Report following a request for further information, negotiations or consultation

REF NO:	P/58/19/PL
LOCATION:	Rear of Inglenook Hotel 253-255 Pagham Road Pagham
PROPOSAL:	Erection of 9 No. dwellings with associated access, parking, cycle & refuse storage & landscape design. This application is a Departure from the Development Plan & may affect the setting of a listed building.

Refuse Vehicle
Swept Path Analysis

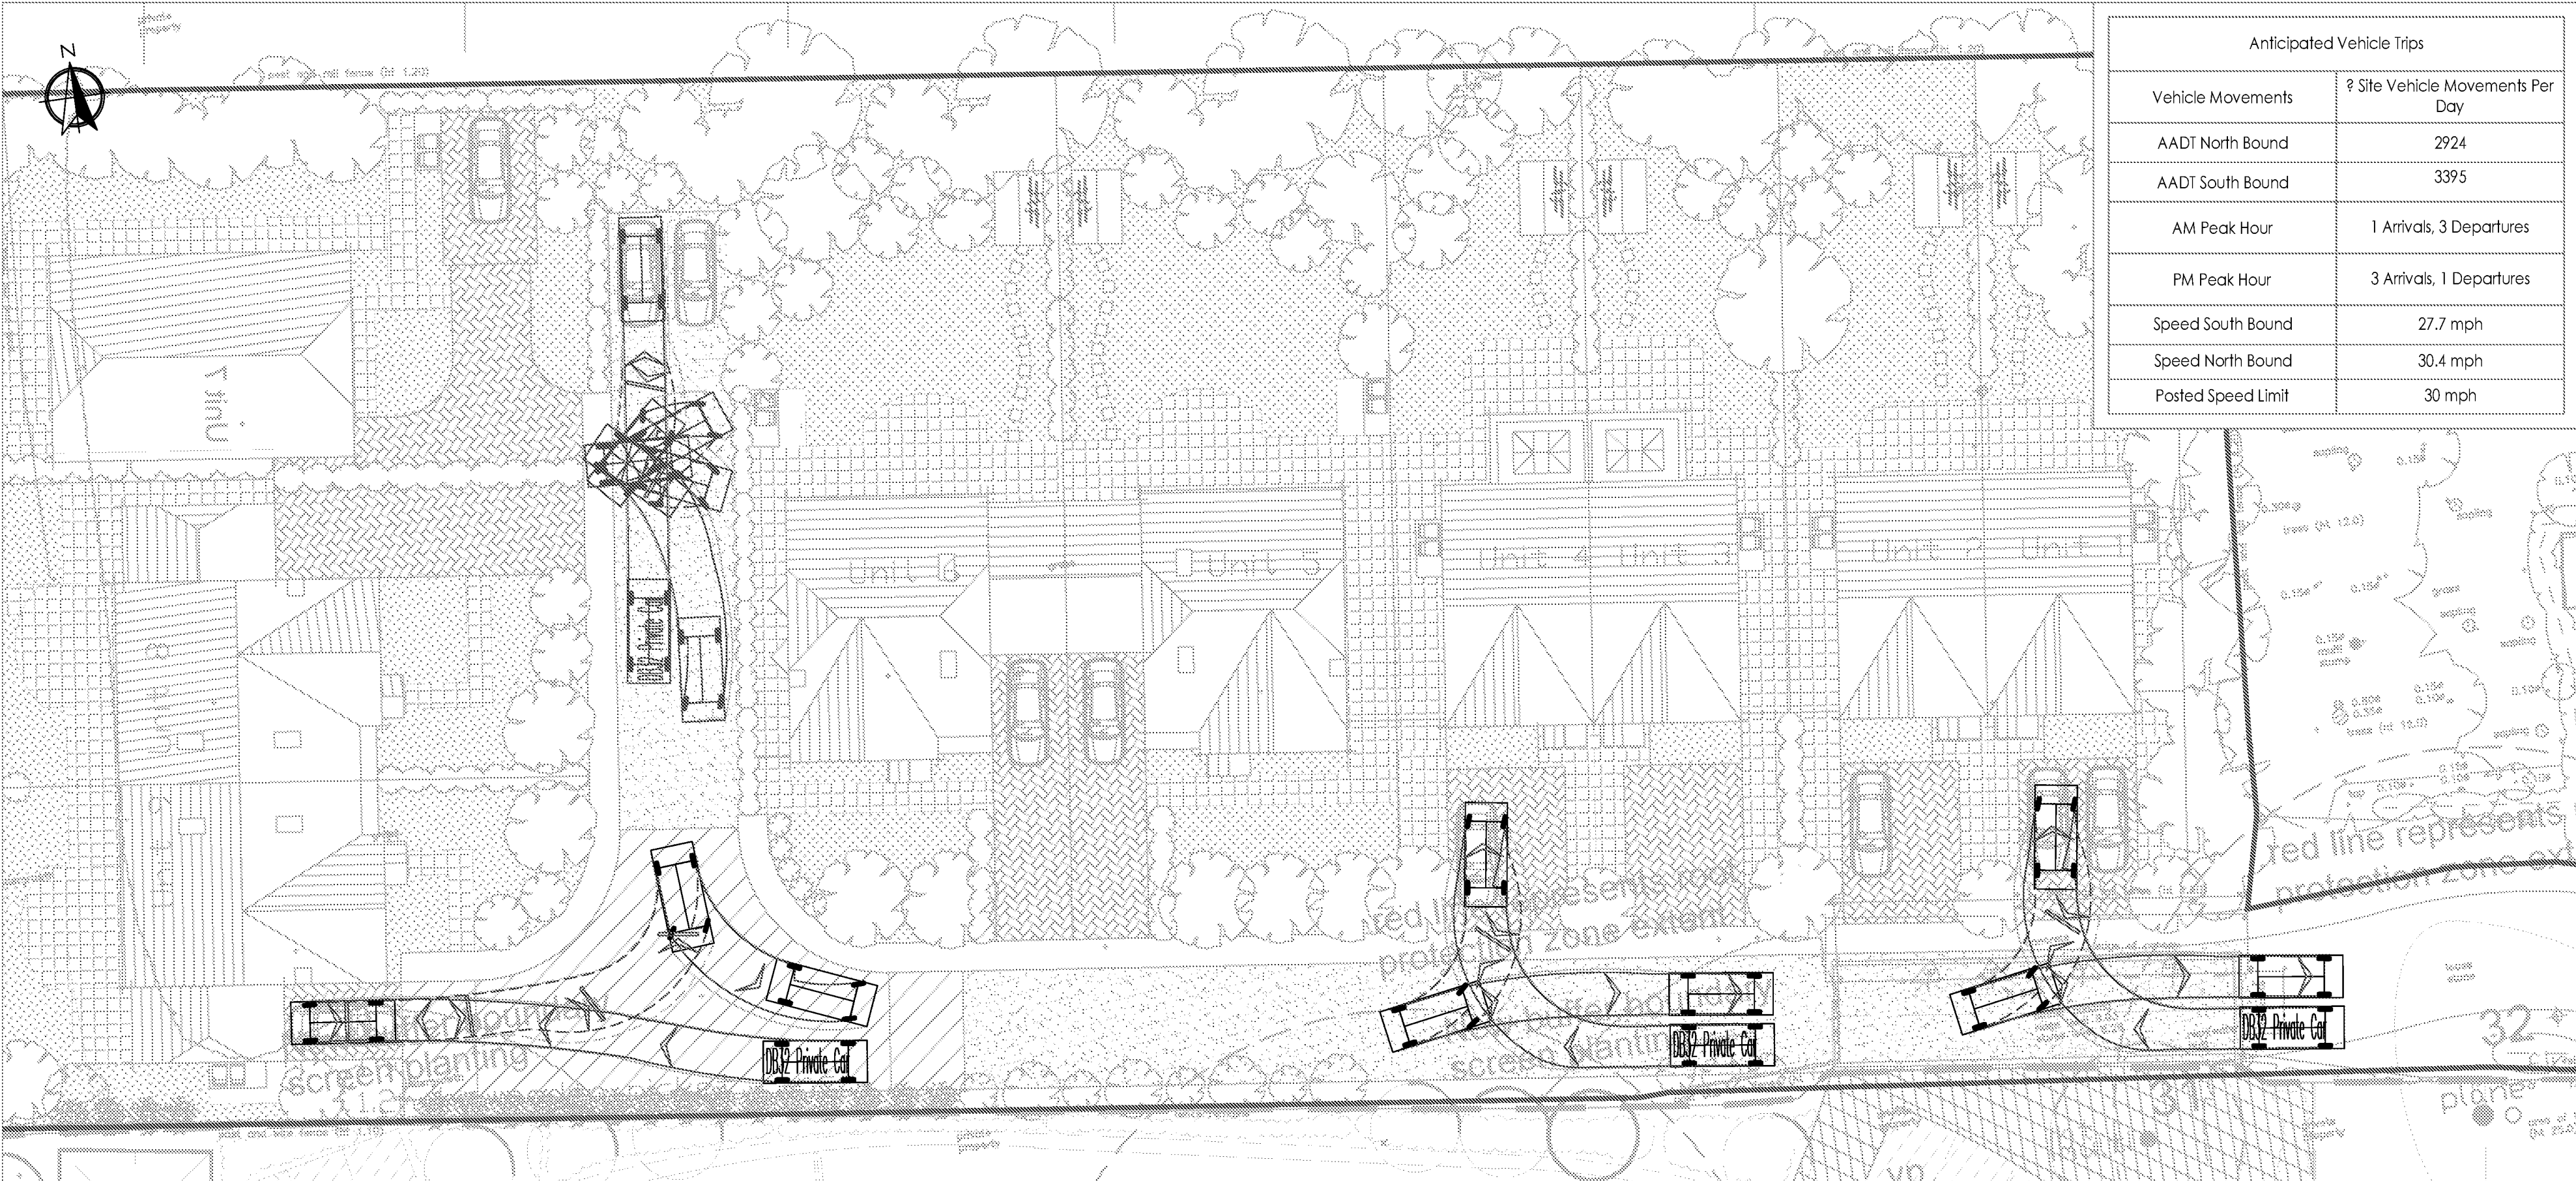
- (4) There does seem to be a trend with collisions at junctions within the area that may present further issues with increased levels of traffic;
- (5) The swept path analysis doesn't take account of any parked vehicles on Pagham Road. There are currently no restrictions and a refuse vehicle would not be able to make a turn with the present arrangements without parking restrictions reducing the existing availability for residents and visitors on-street;

- (5) "The swept path analysis submitted with the application at drawing 2017/3763/003 Rev B demonstrates that refuse vehicles would be able to access and egress the site without issue. In the event that a vehicle is parked on the eastern side of Pagham Road on the section to the north of the access, a refuse vehicle would still be able to turn in / out of the site towards the north given that the access would be widened as part of the proposals."

A	28.11.19	Red boundary amended to include pedestrian access.
REV.	DATE	REVISIONS

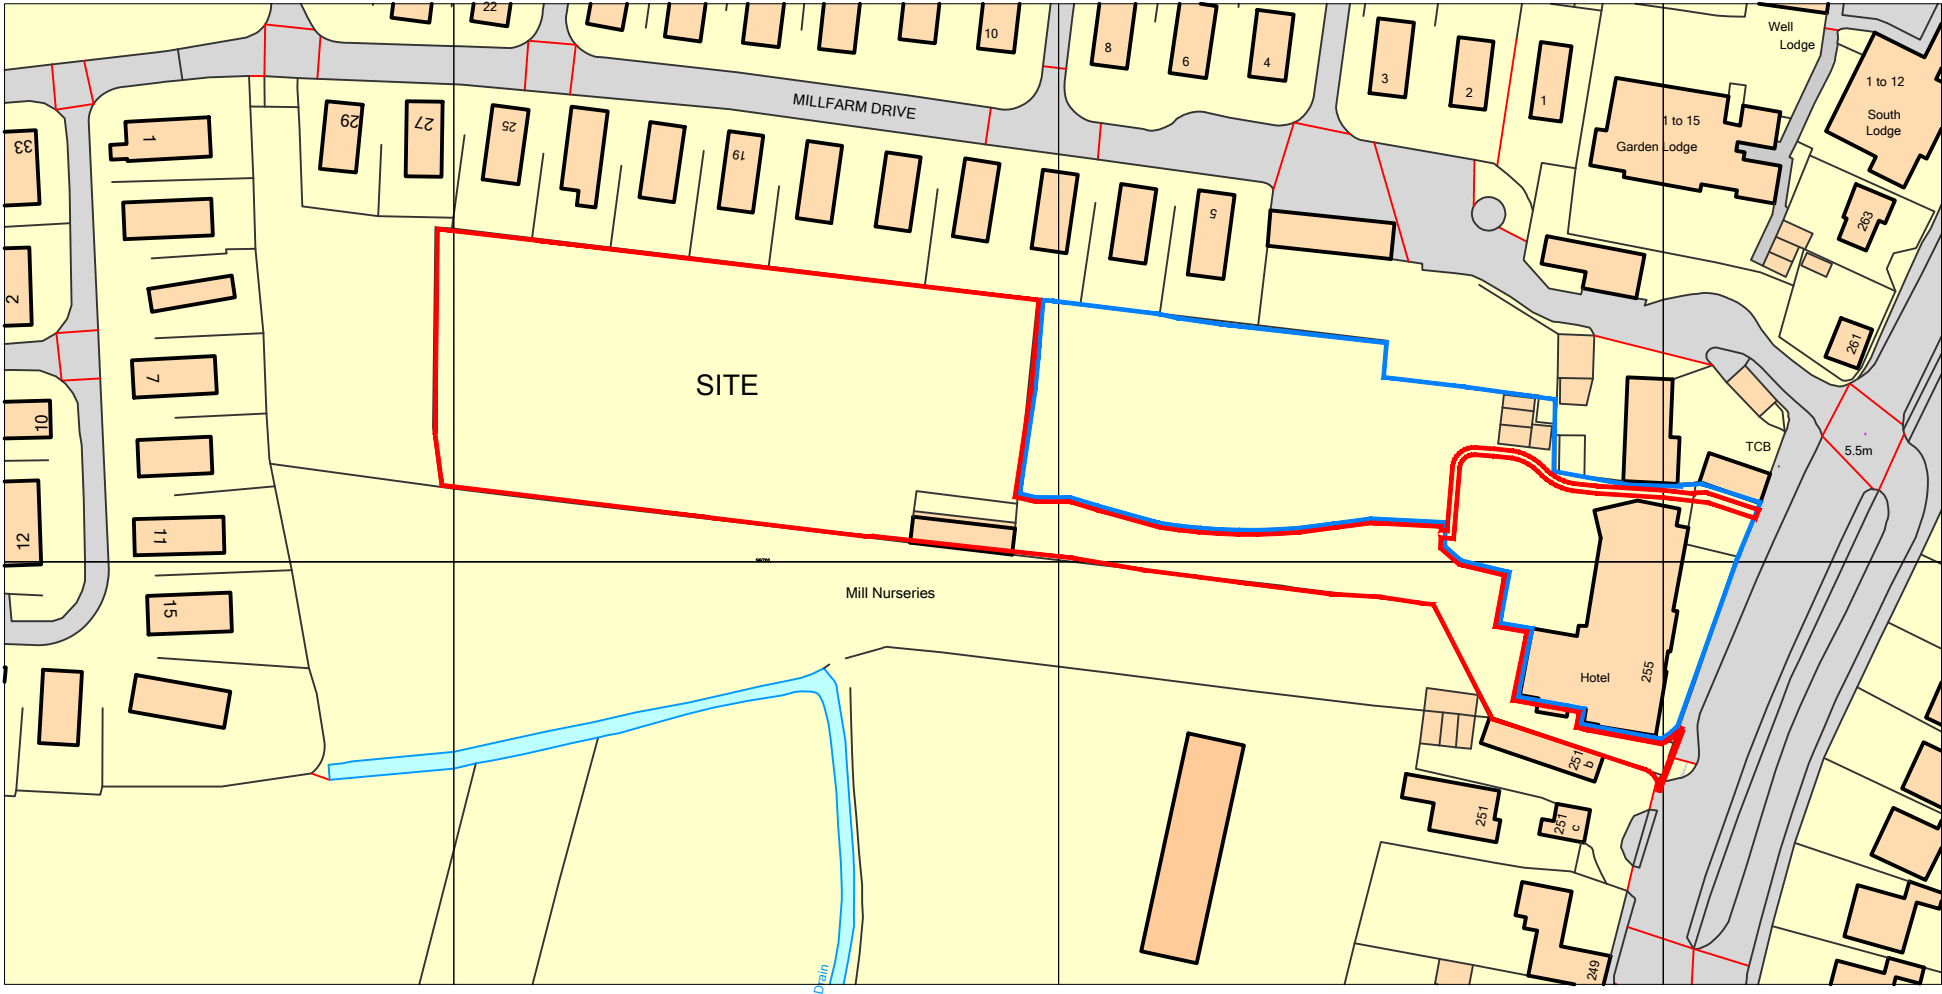
In response, to the site visit by WSCC Highways, the applicant provided an amended site plan (dwg. 13 Rev F) and an amended location plan (dwg. 01 Rev A - 28/11/19) which show the following improvements:

- An alternative pedestrian route is to be provided through the grounds of the hotel from the junction of the pub car park/access road to Pagham Road. This therefore provides an alternative route to the narrowest section of the access drive. This will be surfaced with bonded gravel so as to allow ease of movement by wheelchairs and pushchairs. This will be a resident only route and will be controlled by a key/pin code on a gate.
- Removal of 2 small category C Conifer trees from their position adjacent to the access drive/opposite the existing pub car park entrance to improve forward visibility.
- Provision of a bonded gravel pavement on the shared access drive to separate the pedestrian and vehicle sections.
- Provision of signage to advise vehicles entering the access drive from Pagham Road to expect pedestrians in the road.

- Concerned that the alternative pedestrian route will not be fully used as it is not a direct route. It may also not be perceived as safe particularly at night or when the pub is busy.
- The proposed new pedestrian access is situated where deliveries are currently received to the pub and this would lead to an unacceptable mix of vulnerable pedestrians and large vehicles in the same area.
- Despite the use of a bonded gravel pavement and signage, the shared drive will still not be safe for pedestrians as cars will be able to enter this space. Lighting is also necessary.

WSCC Highways have appraised the applicants proposed changes to the plans and advised that the modifications will result in an improvement to the overall accessibility and internal layout of the site for pedestrians. On this basis, WSCC raised no objection to the changes.
